Ian Maguire
Assistant Director Planning
& Economic Growth
Floor 4, Core 2-4
Guildhall Square
Portsmouth
PO1 2AL

@portsmouthcc.gov.uk
Our Ref: 20210125
Date: 25/01/21

RE: Deadline 7 Submission in respect of the Application by AQUIND Limited for an Order granting Development Consent for the AQUIND Interconnector Project.

Figure 10: Affected area – Jct. A2030 / Fitzherbert Rd – Portsmouth (on exit from Sainsbury Car Park / Direction of travel of the abnormal load).

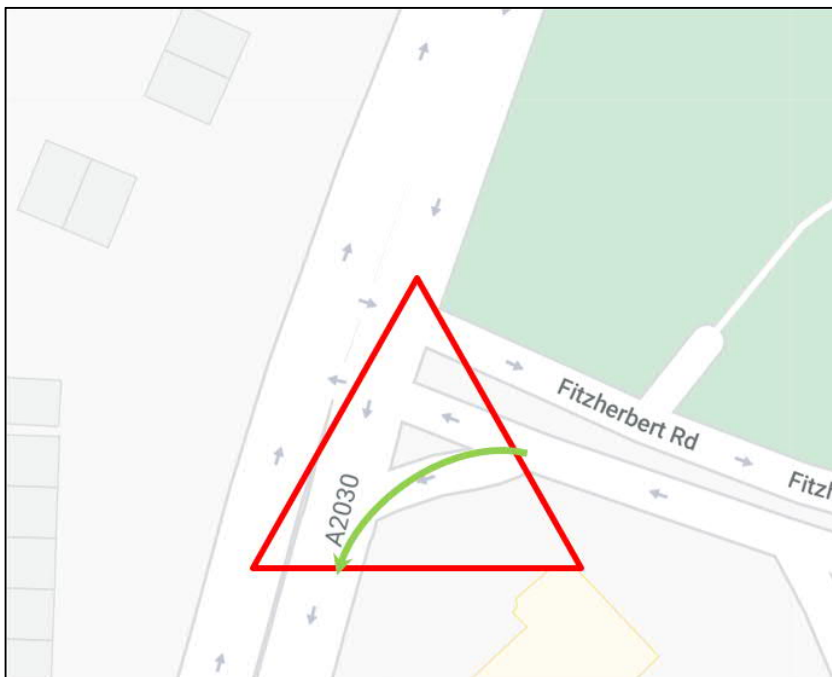
- Eastern Road/Fitzherbert Road - two poles will be removed and relocated to the back of the footway with new pole retention sockets placed in the existing pole locations, which will be used to permanently reinstate the posts once all abnormal deliveries have been carried out.

- 1.38 Whilst the measures are acceptable, PCC note that in practice any alterations to traffic signals will need to be carried out by Colas ITS as the term contractor in Portsmouth. The extent of works will need to be agreed with and costs for works payable to Colas prior to any works being carried out as described in this document. It is envisaged that the need for such works would be established and agreed upon submission of a Provisional Advance Authorisation (PAA) under the Portsmouth Permit Scheme.

Figure 12: Affected area – Fitzherbert Rd – Sainsbury Entrance / Exit Portsmouth / Direction of travel of the abnormal load

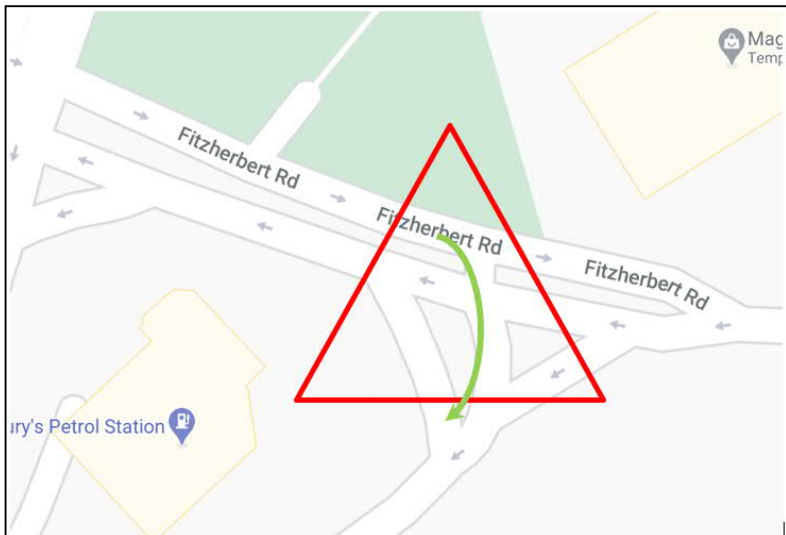
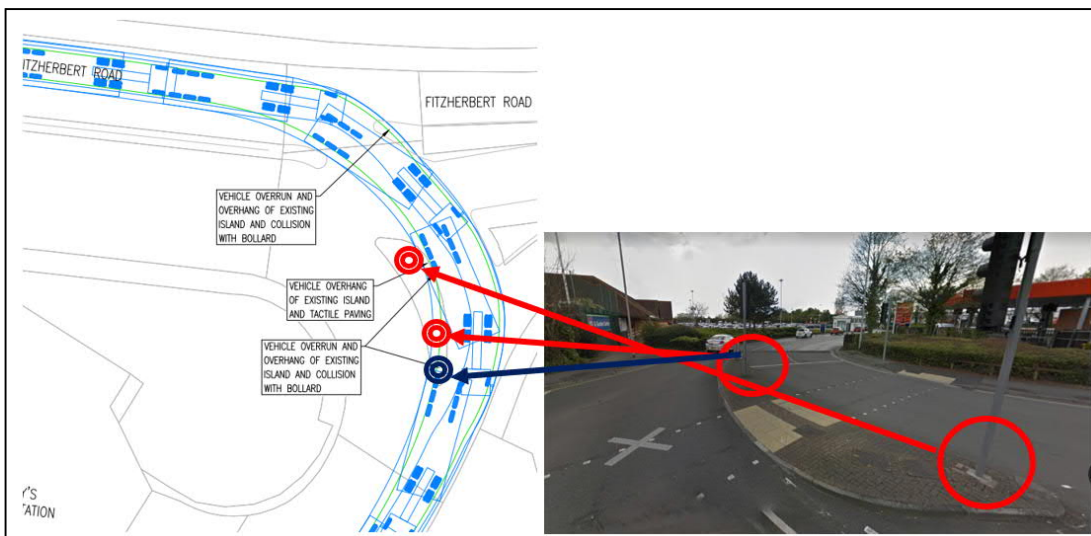
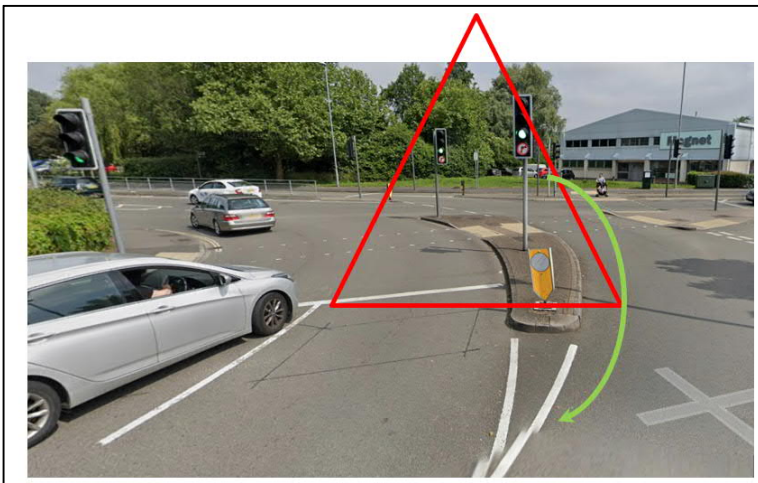
- Fitzherbert Road/Sainsbury's access - two poles to be removed, however these are located on a central island and as such two new poles will need to be installed into new pole retention sockets (this will also represent the final reinstatement) and removed for each occasion an abnormal load requires access to the Sainsbury's car park.

Furthermore, a collapsible bollard located on the traffic island is also required to be removed/replaced on an ad-hoc basis.
